Planning Application Reference No.: 3/2022/1129

Address of Development: Martholme Greenway

I write in objection to this Retrospective Planning Application 3/2022/1129 regarding the Land at the Old Track Bed, Bridge Heywood Caravan Park, Whalley Road, Read. i.e. The application is for retrospective change of use with minor engineering works and associated landscaping works for the reuse of the former railway embankment and track bed to form an informal recreational amenity area in association with the adjacent holiday park.

Site Plan

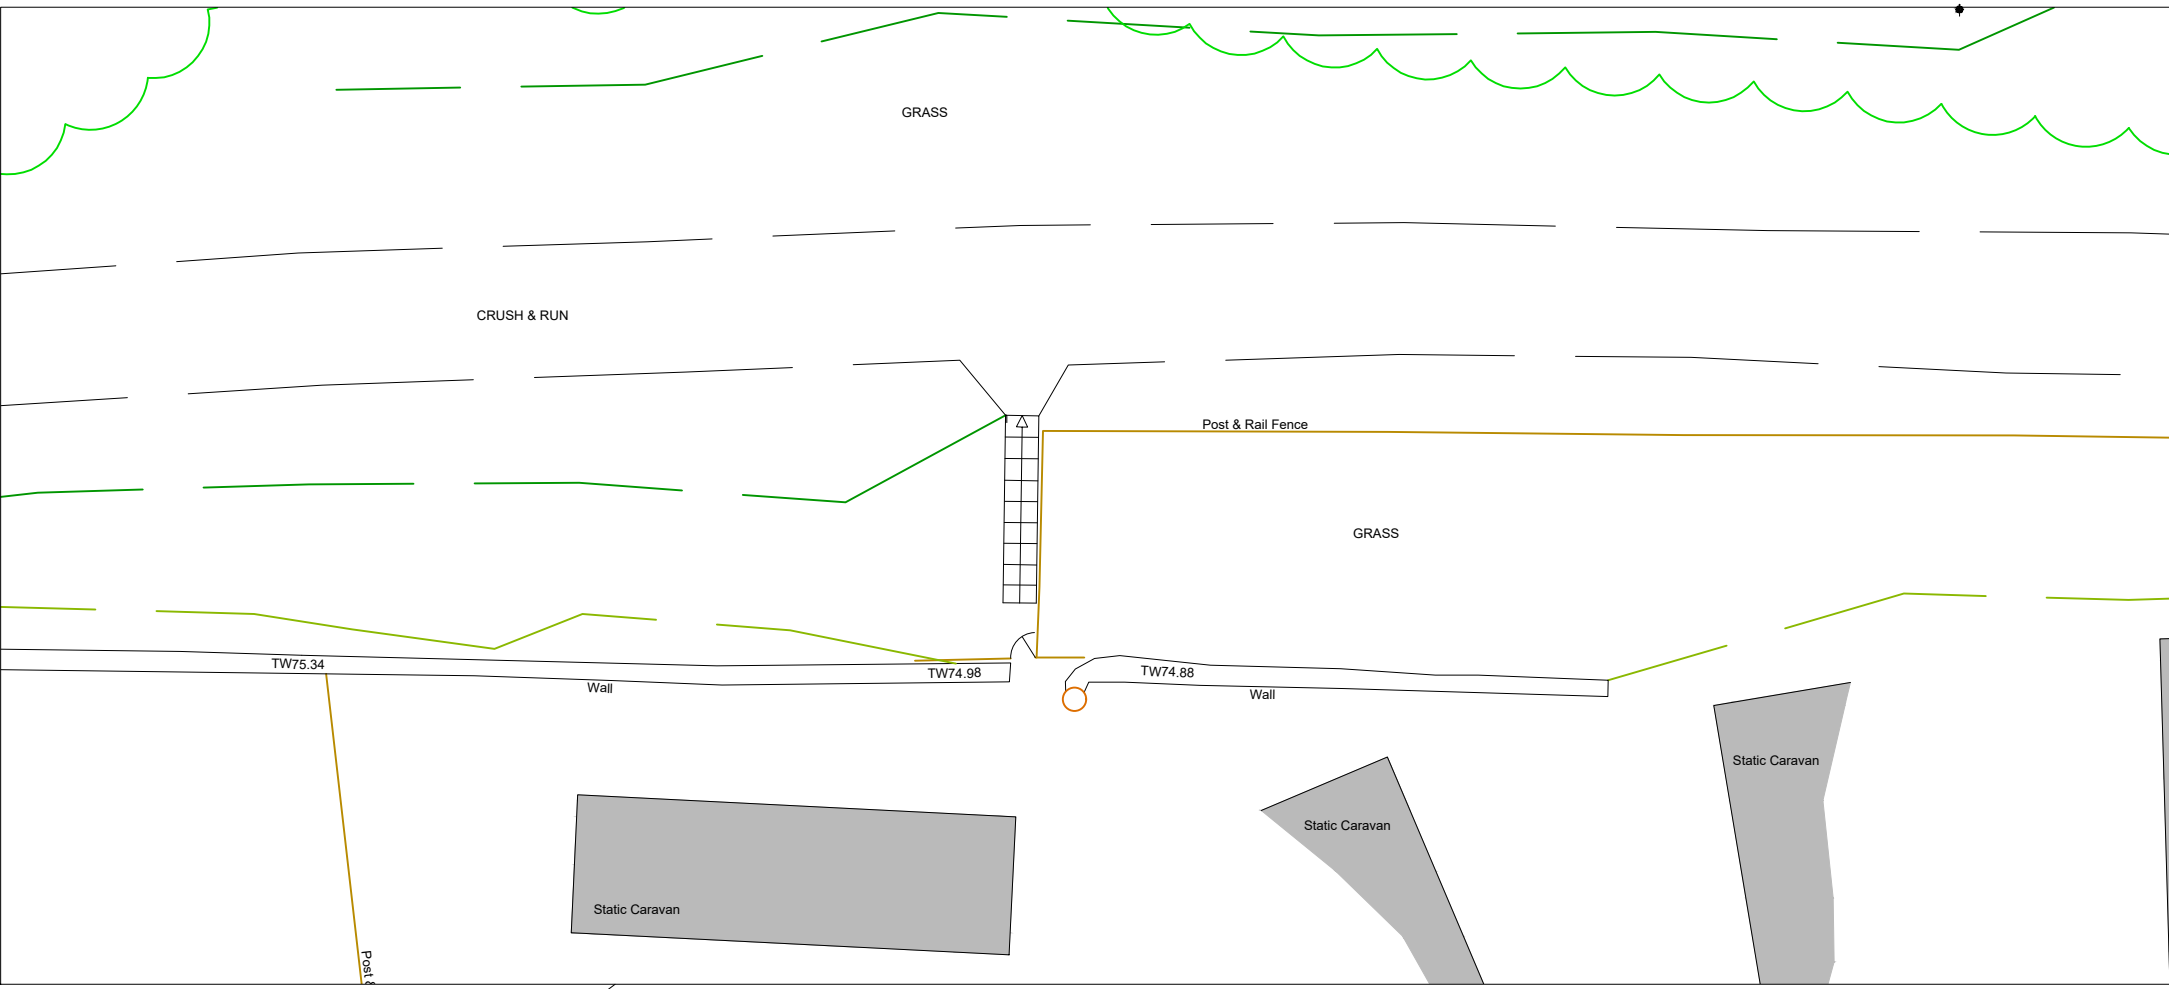
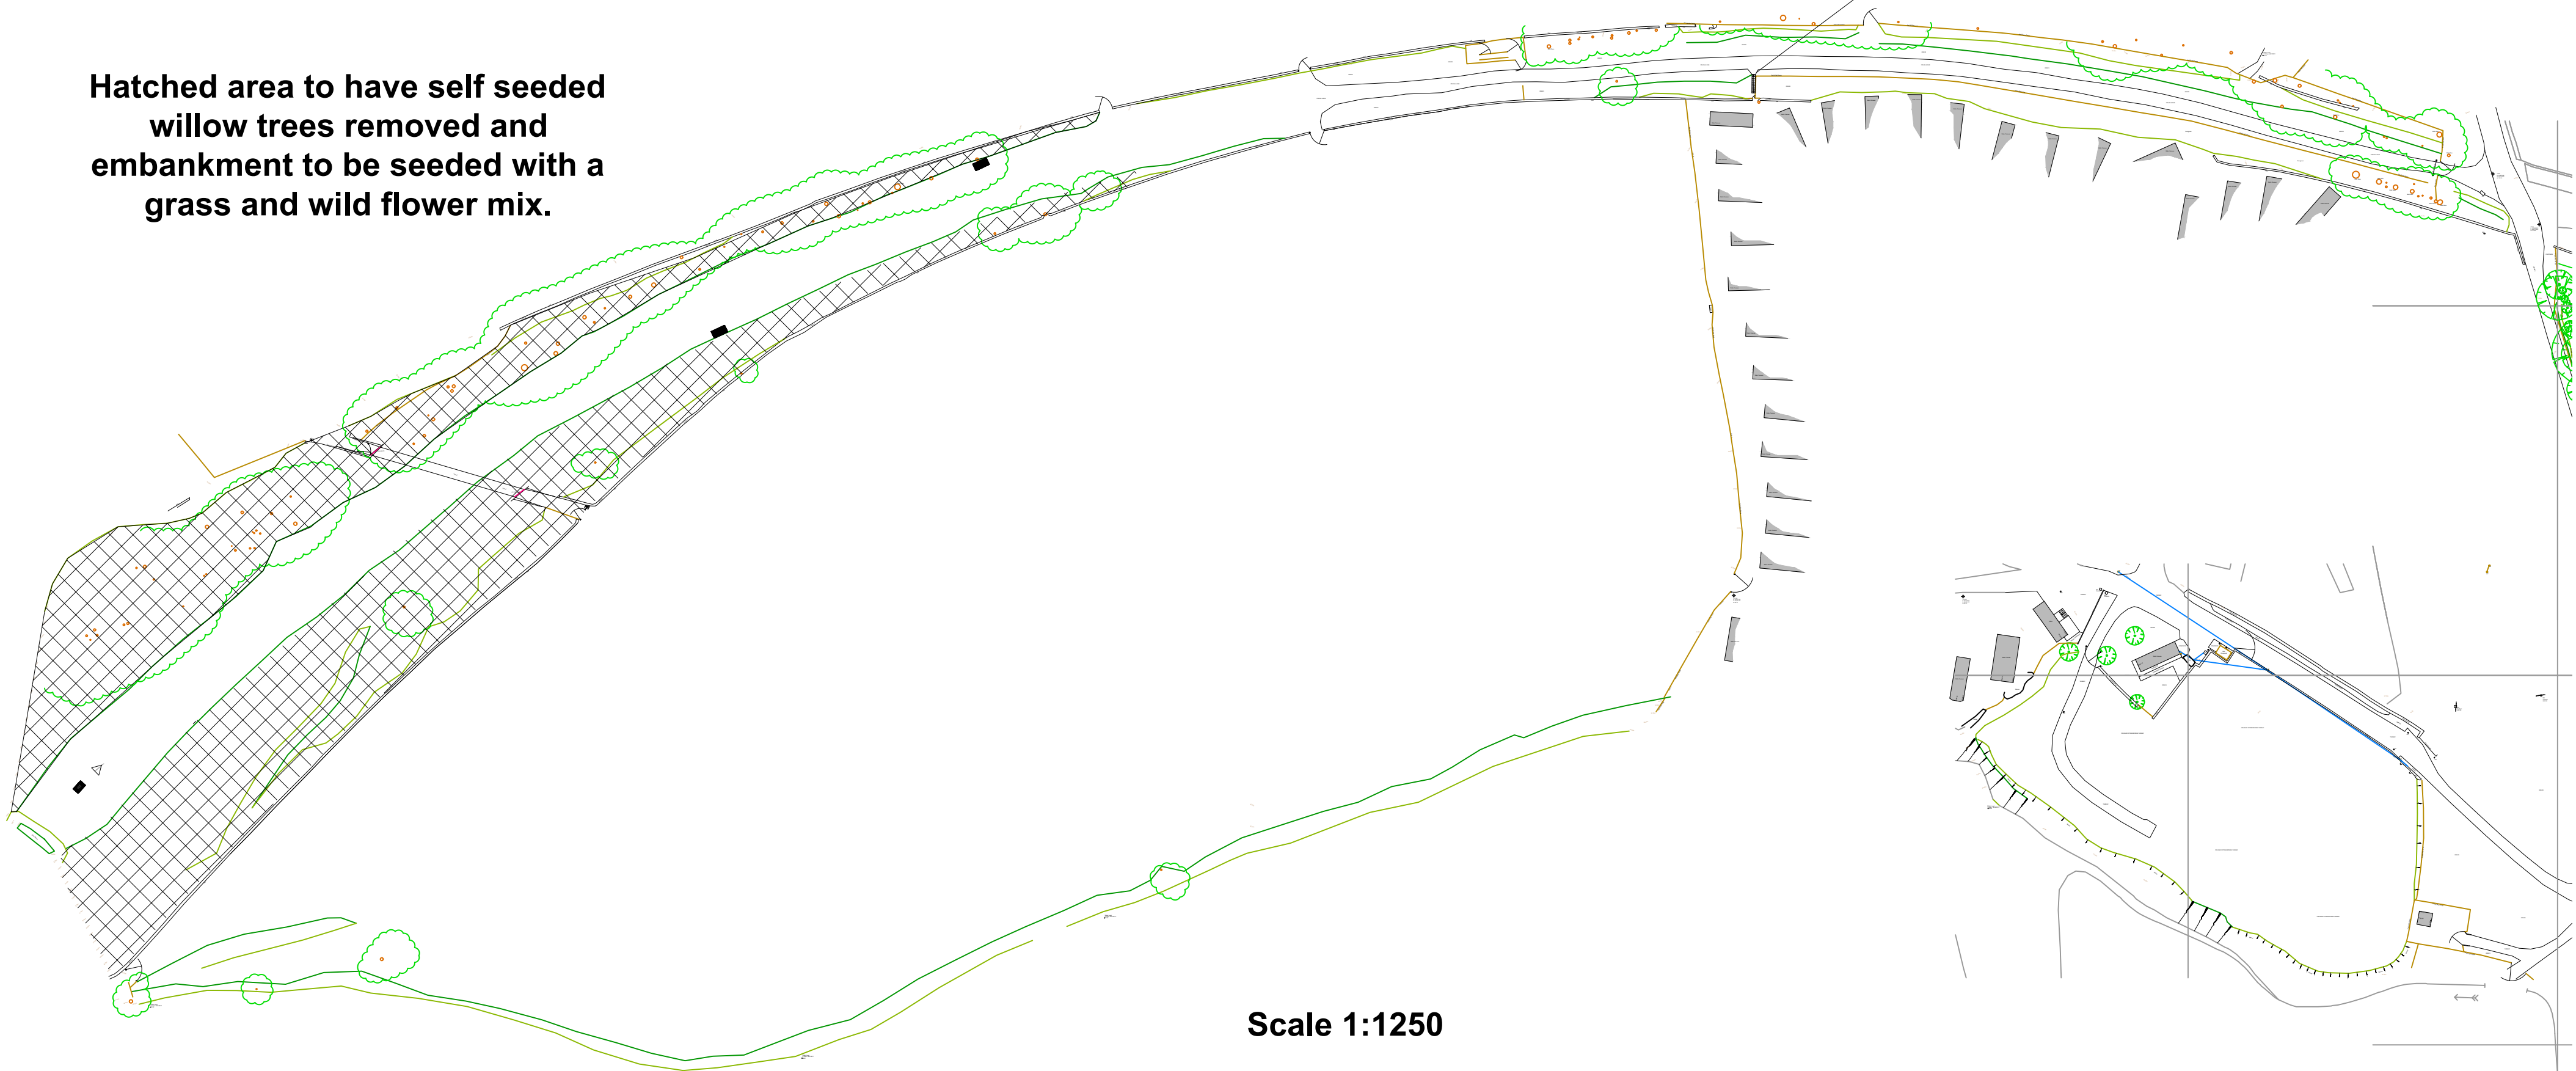
Access to the Viaduct has always been fully accessible from the Southern end, so to state on the Land Owner's map that the Viaduct is "NO ACCESS OVER THE VIADUCT" is incorrect and only made non accessible by the Landowner himself. The "Bridge Heywood Woodland Walk Map". shown on his map also includes land that is not owned by the Landowner, but by Railway Paths Ltd. On the deed there is no permitted access for Caravan residents, so this part of the walk should not be included in these designated Nature Walks.
